Comment for planning application 23/00750/TEL56

Application Number	23/00750/TEL56
Location	Street Record Station Road Kirtlington
Proposal	Proposed telecommunications installation: Proposed 15.0m Phase 9 slimline Monopole and associated ancillary works
Case Officer

Organisation Name	Mrs Elizabeth Russell
Address	The Glebe, Troy Lane, Kirtlington, Kidlington, OX5 3HA
Type of Comment	Objection
Type	neighbour

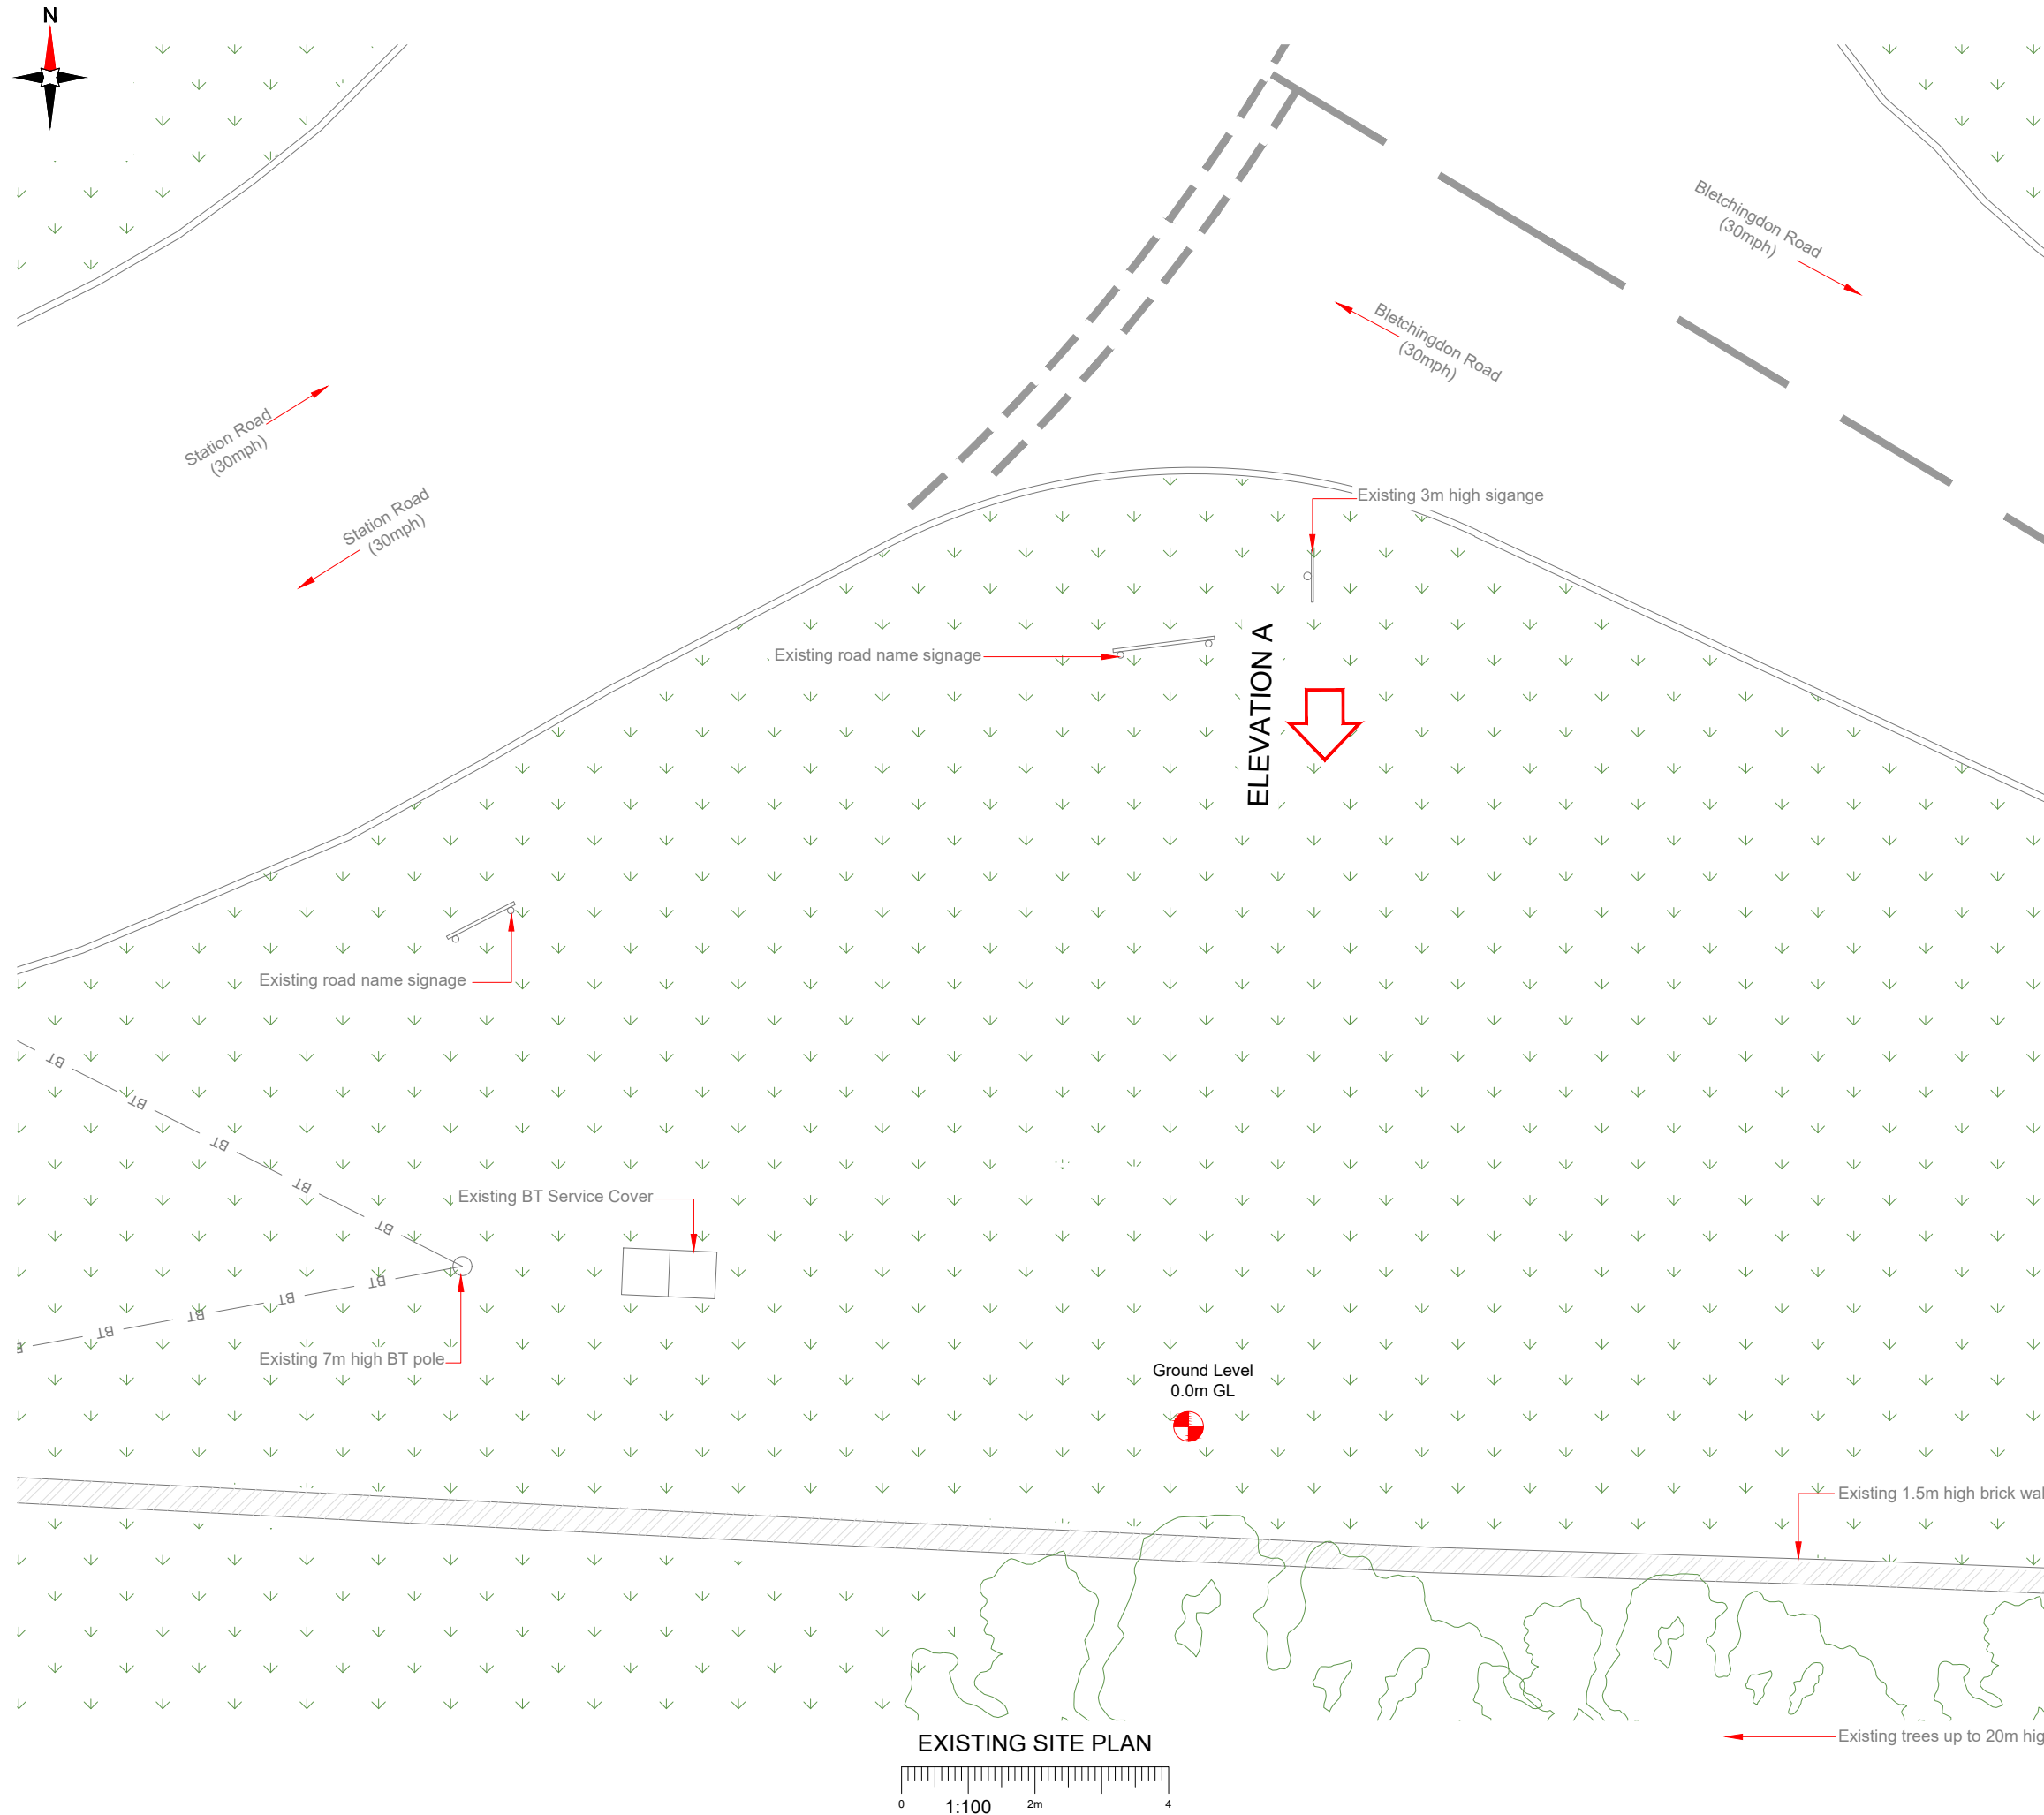
10. Site location plans:

Each photograph is taken to show zero residential properties, and each diagram shows a tall tree. Firstly, the photographs are completely misleading being taken from these angles. Please see attached photographs to see residential properties within meters of site. Secondly, to be reliant on that tree standing forever is irresponsible and unrealistic. These are large old trees which will come to the end of their lives. In addition, there is no photography to show the actual look of the mast, meaning the application does not show the true impact of how invasive this structure will be to the whole village.

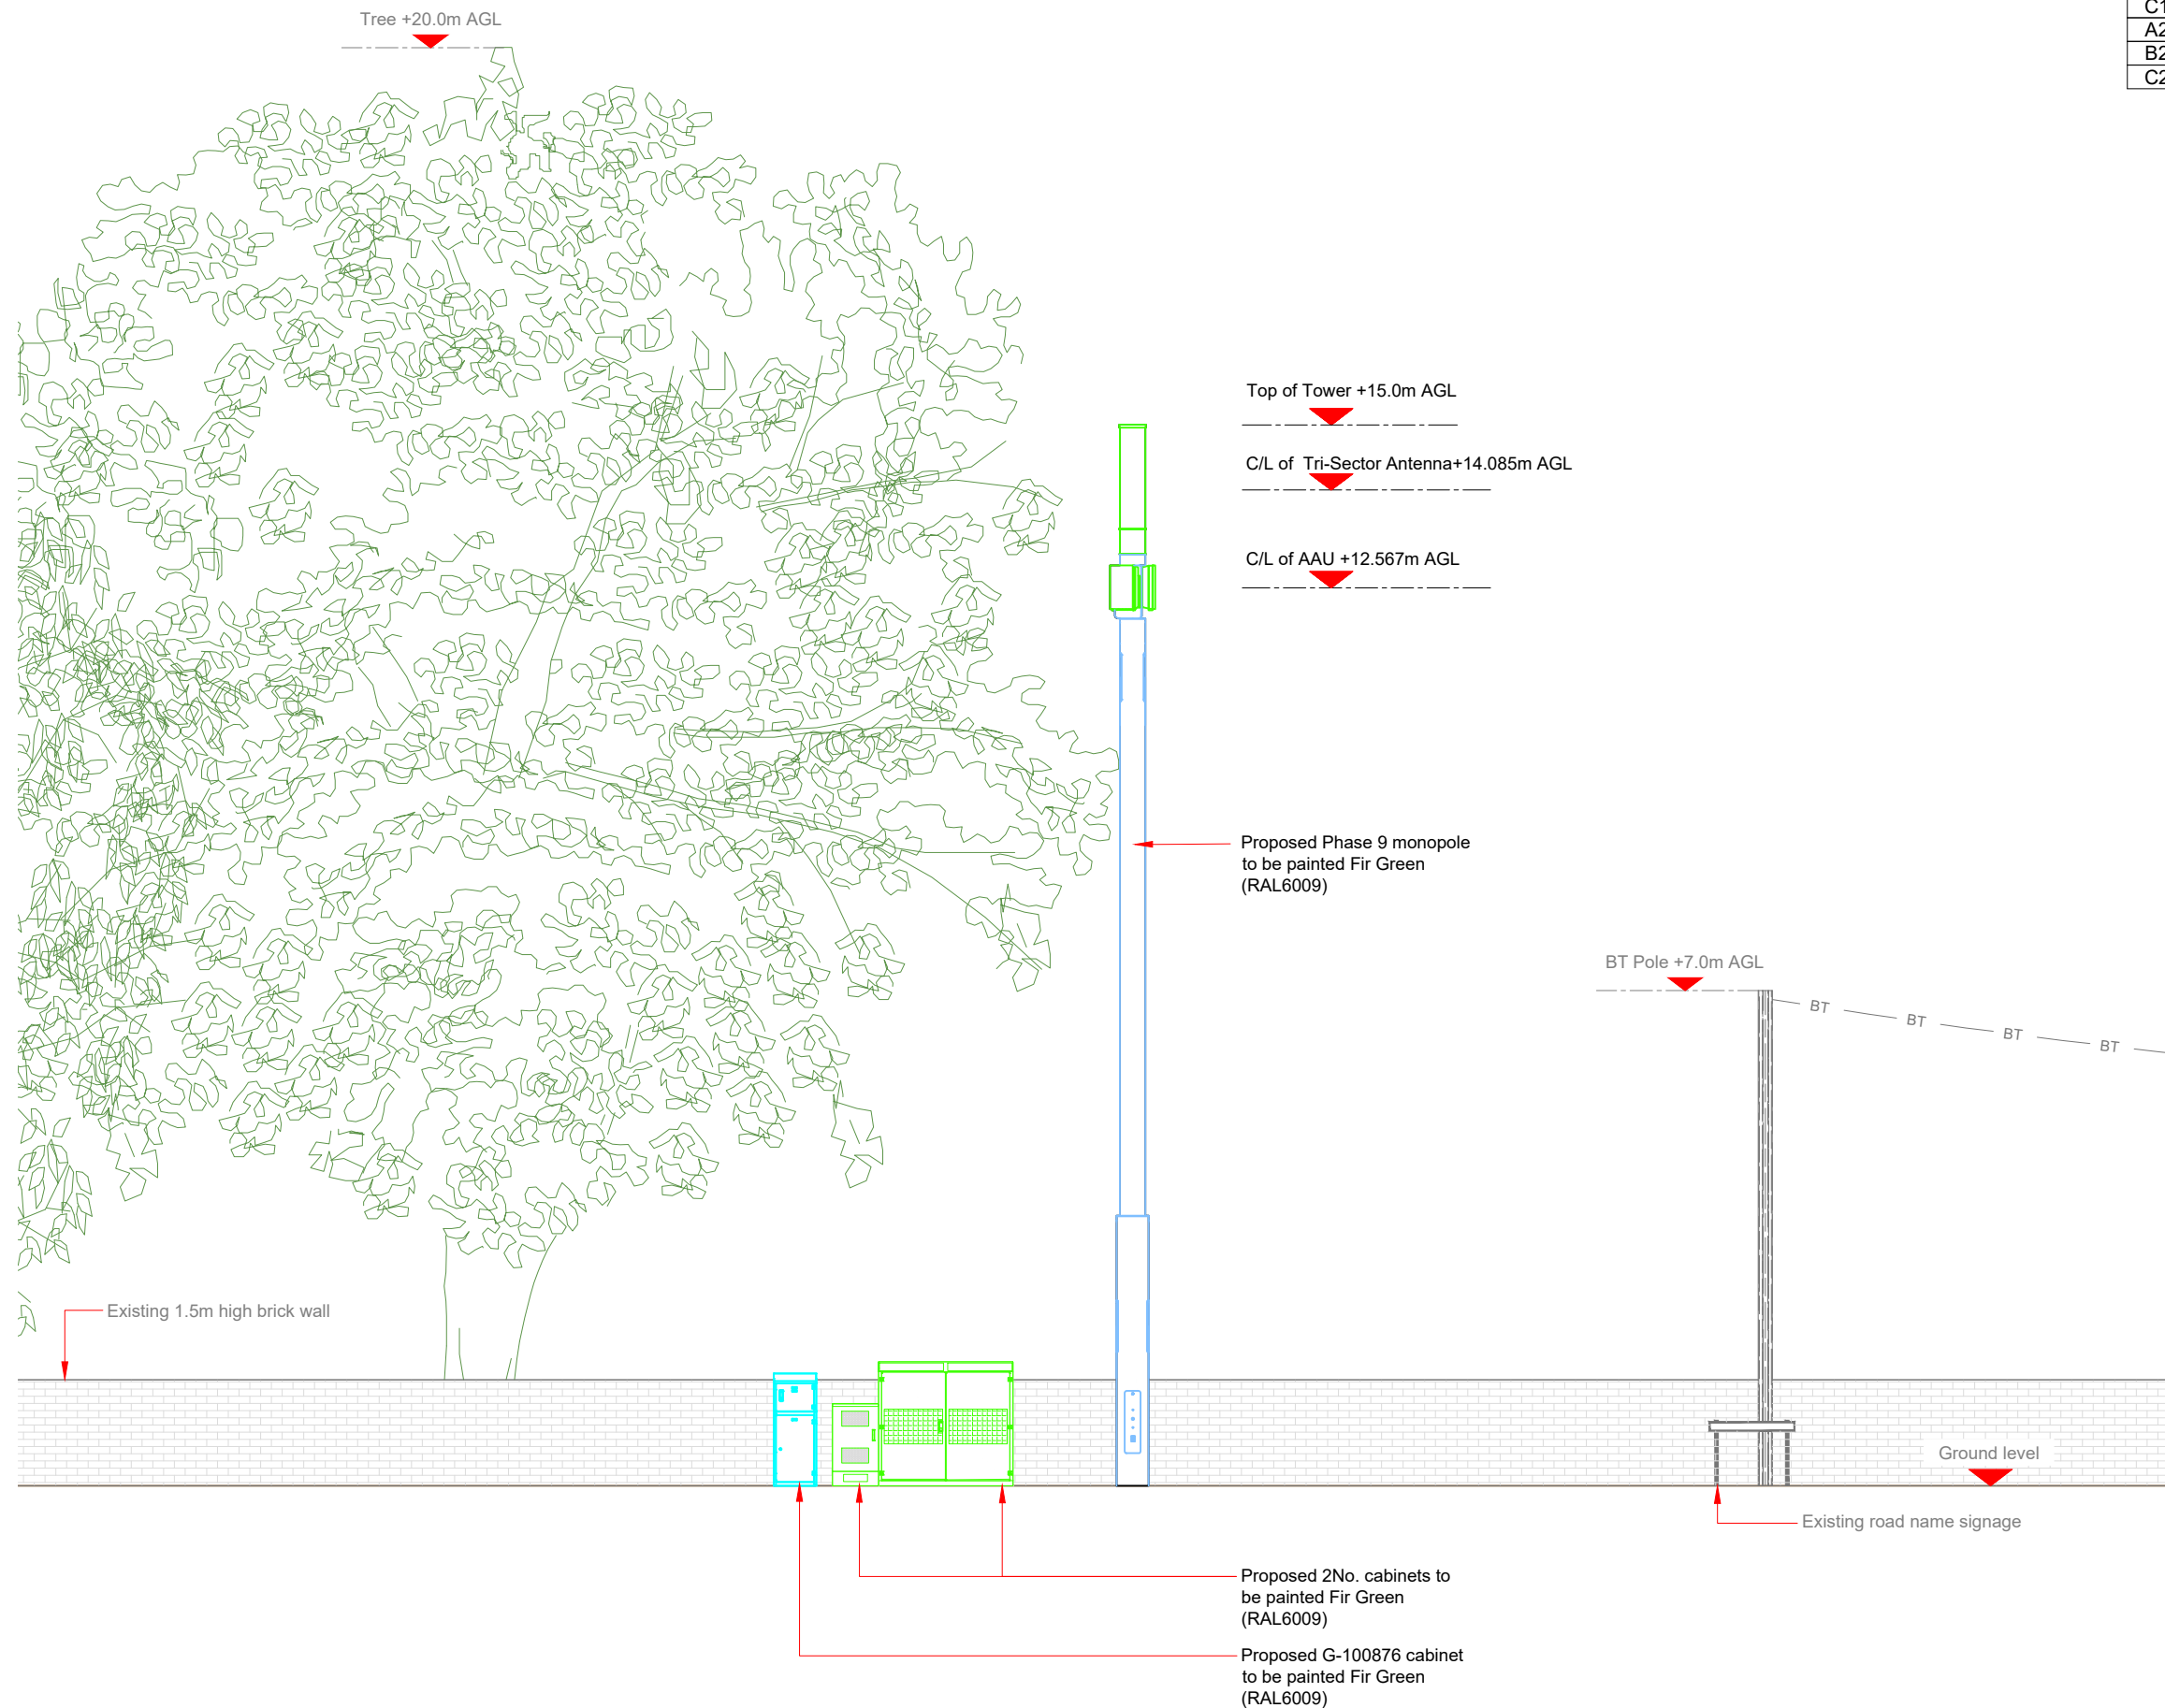
Overall I am astounded at the misleading nature of this planning application, in its plan drawings (of existing and proposed) including lack of details both in what the mast will look like bar a misleading drawing against a tree (which is only from one angle), and photography that shows very little of the actual area - including NONE of the surrounding houses who will be in direct line of the mast. The very fact that once again next to no one knows about it or was contacted officially suggests the proposers are trying to get it through under radar again. It was only brought to my attention due to one resident being sent a letter. It is now on Kirtlington village facebook in the hope, that before the holidays start, people object in time.

Figure 5:

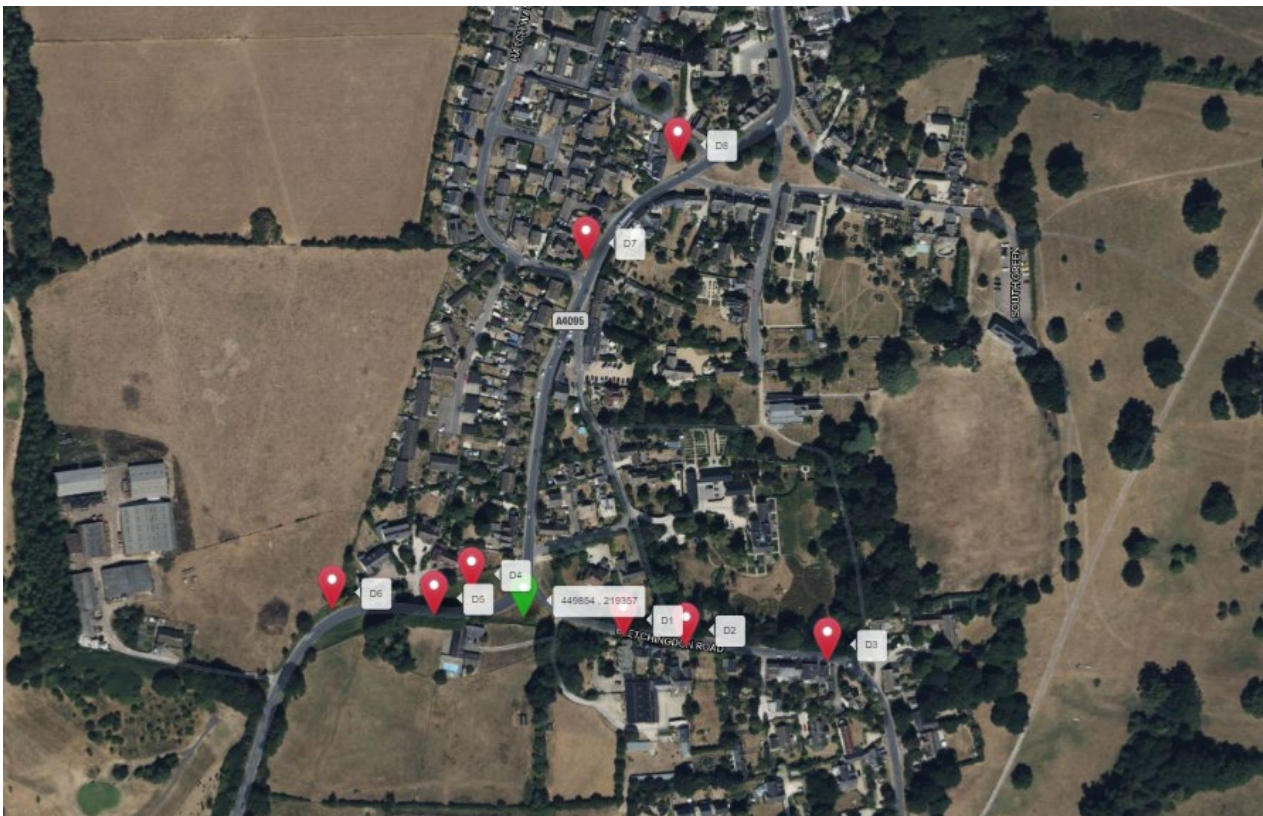
If you look at these and the map, they are all listed as : "highly visible from onlooking residential properties" INCLUDING the site they are proposing: "D4 - 449819 , 219374, Grass verge adjacent to Oxford Road discounted due to lack of screening. Site is highly visible from onlooking residential properties."

They have said themselves this site should be discounted! (see attached and photograph on application).
